Application No: CM/70/21/PL  
Site Address: Land at Wren Cottage Horsemere Green Lane Climping BN17 5QZ  
Description of works: Subdivision of the plot and construction of 3 detached bungalows with associated parking, access and landscaping (resubmission of CM/17/21/PL). This application is in CIL Zone 3 and is CIL Liable as new dwellings.

Thank you for your internet representation made on 12th December 2021 which has been recorded as an objection with the comments as follows:

Title
Location & Block Plan

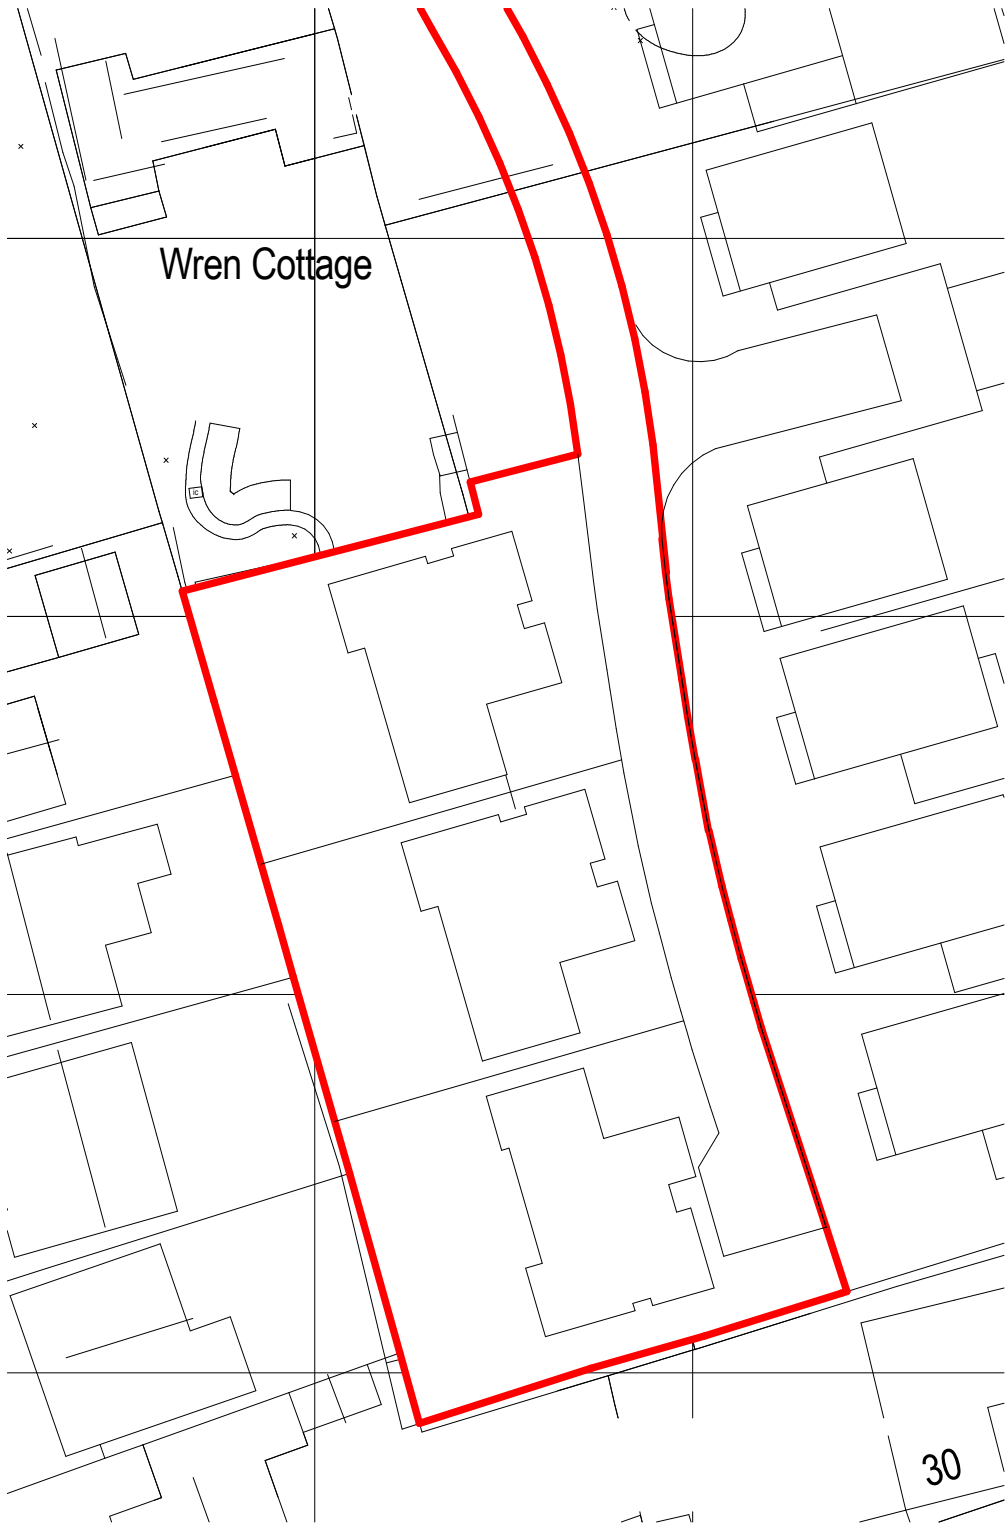
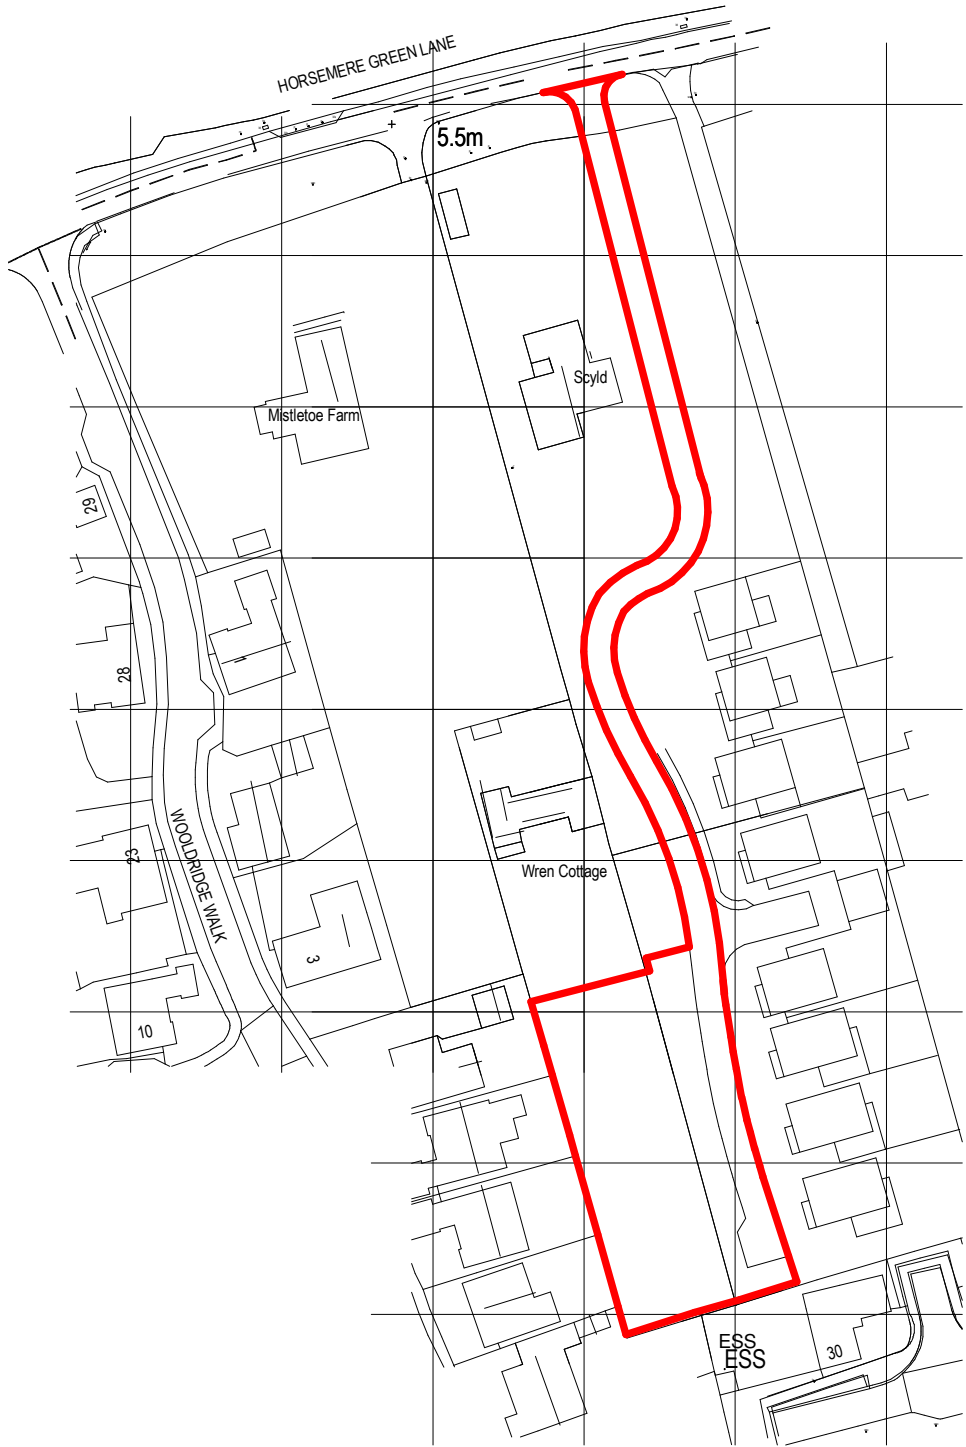
Having perused the resubmitted plans for wren Cottage , our objections are as follows:  
Plot no 3 is still too close to our property as spelt out in the previous refusal, the plans are showing a garden of 10.653 metres but in reality it is only approx 8 metres, the reason being the measurements on the official land registry when we purchased our property to the boundary line as confirmed as being 10 metres, the fact that we have an in-garden fence which was erected in front of our conifers was purely for aesthetics and ease of maintenance .So their measurements do not show a true boundary perimeter which we will be confirming with Lizard Landscape Design to clarify where they obtained their measurements, and the fact that the conifers were planted within our boundary by the previous owner of this property and are nothing to do with Wren Cottage. By looking at photo no 4 on the Lizard Landscape report iyou will see it shows a definite boundary fence with the conifers on the Wooldridge Walk side of the fence, unfortunately over time the fence has been removed and this is obviously where the confusion lies. To round off this objection surely anyone can see the garden of plot no 3 is too small for what is being proposed .
